Ms Deborah Shaw
Project Manager
St John of God Health Care
13 Grantham Street
Burwood NSW 2134

**St John of God Richmond Hospital Redevelopment (SSD-10394)
Response to Submissions**

Figure 11 Noise Prediction Map

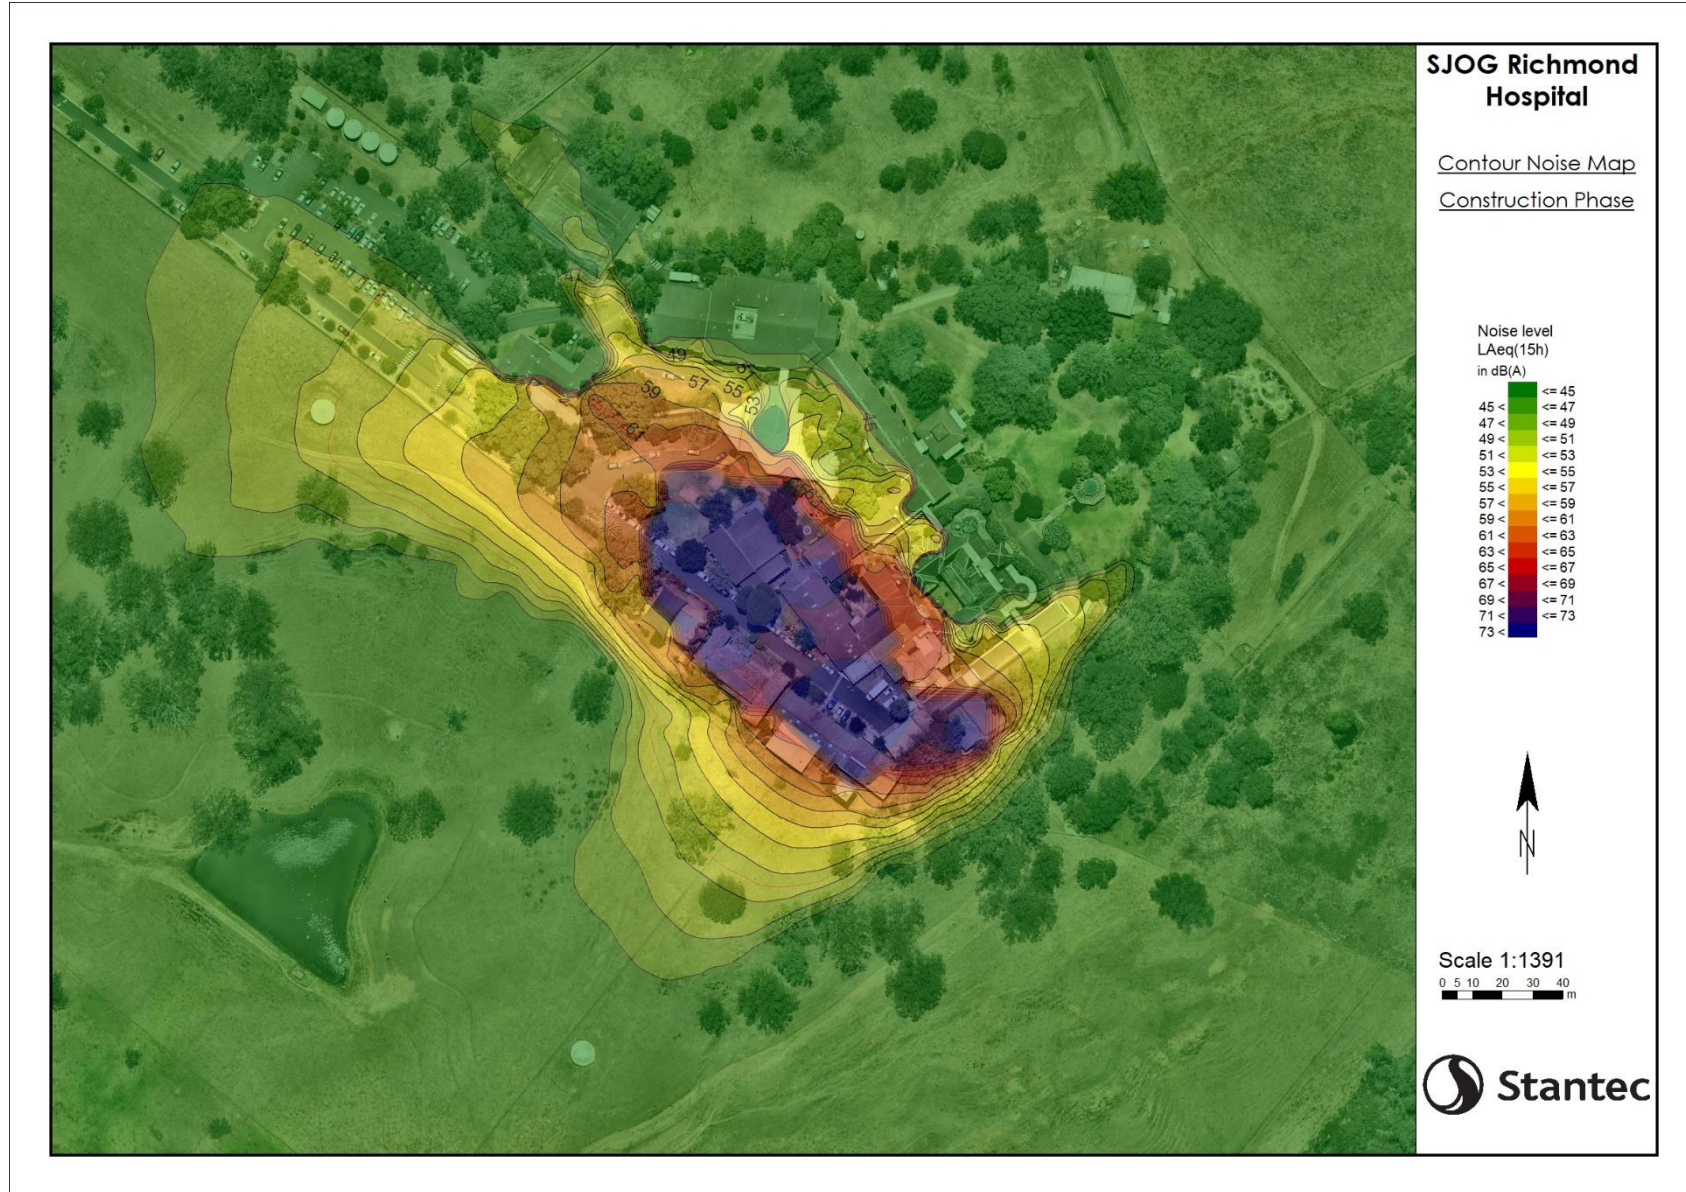
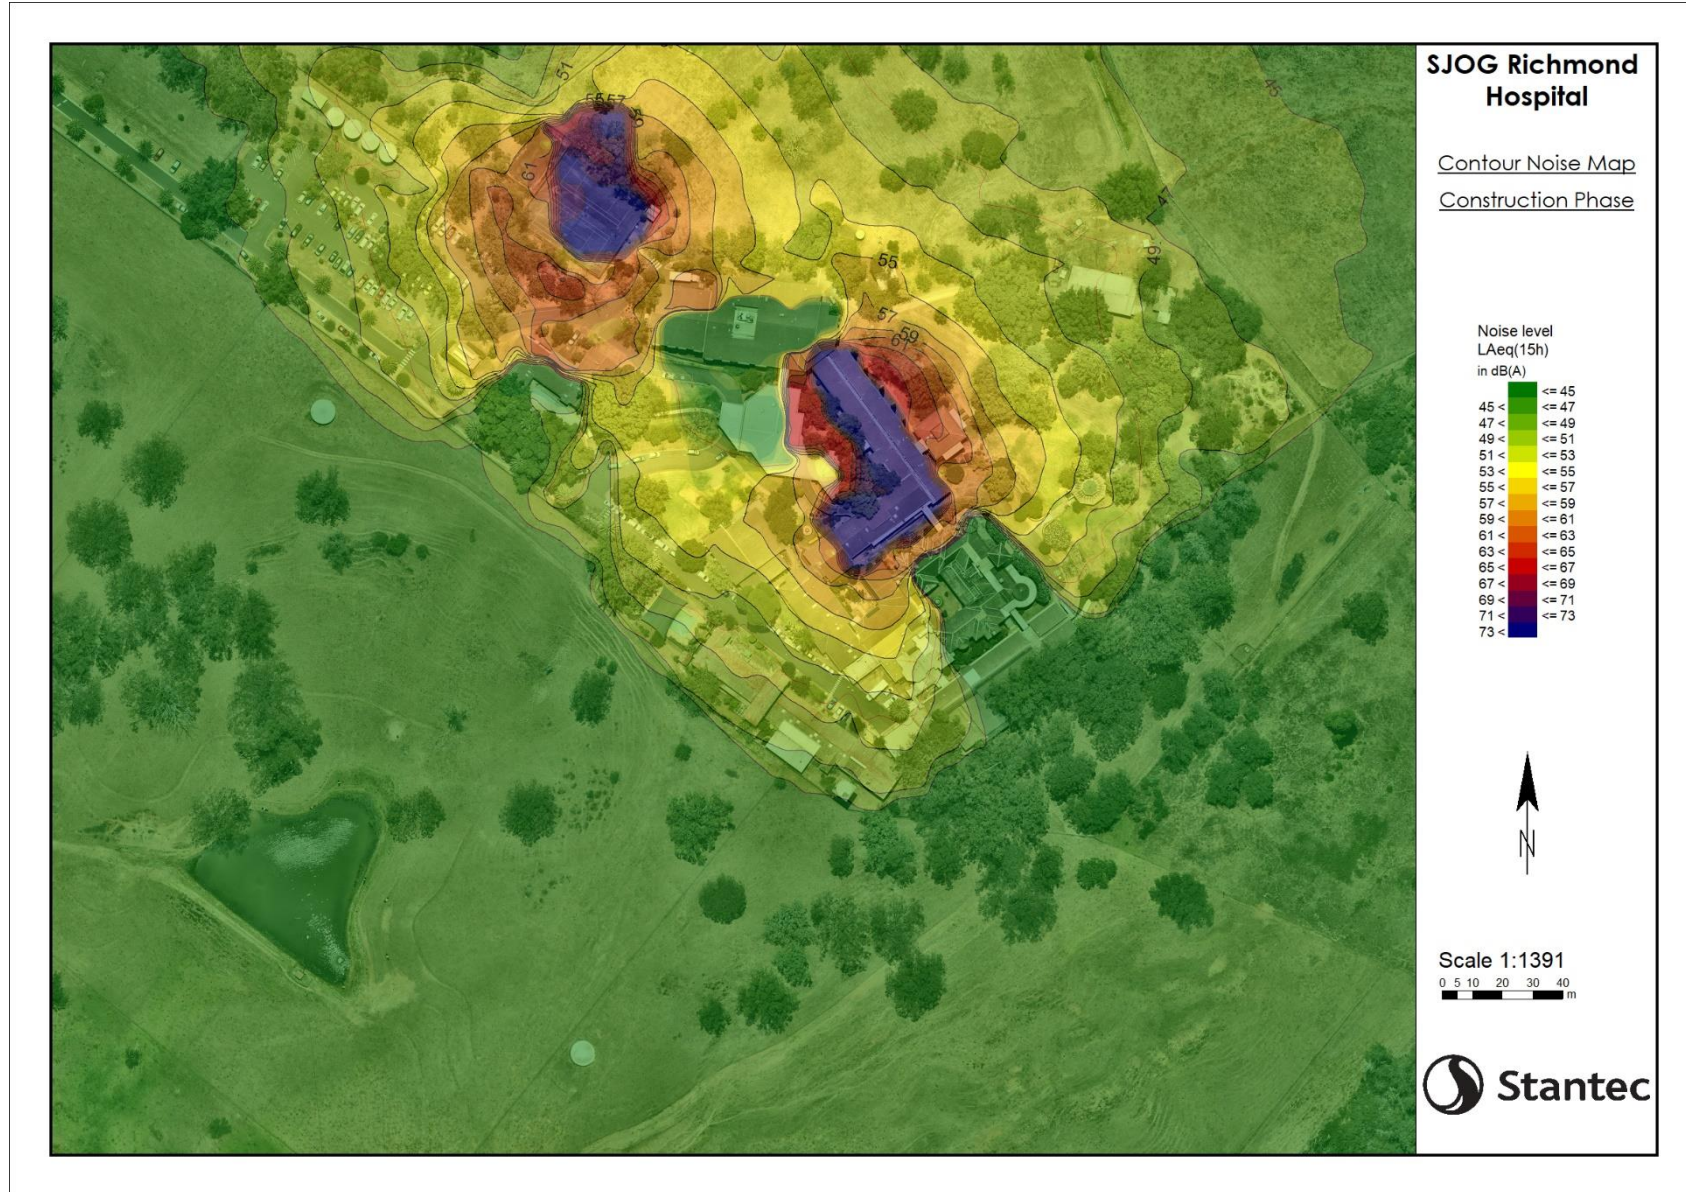
- Table 11, 12 and 13 of the construction noise report are to demonstrate the receiver locations as their positions on the subject site are unclear.
- consideration should be given to providing openable windows within communal areas to provide natural ventilation and cooling, rather than the use of mechanical air conditioning at all times.
- the clause 4.6 variation (Appendix 14) is to be amended to appropriately reference the height variation being sought (not FSR), and the height of existing structures is also to be provided for comparison purposes.
- consideration should be given to whether an updated Emergency Response Plan is required that accounts for the proposed increase in patient capacity at the facility, with particular attention given to flood evacuation procedures and practices.
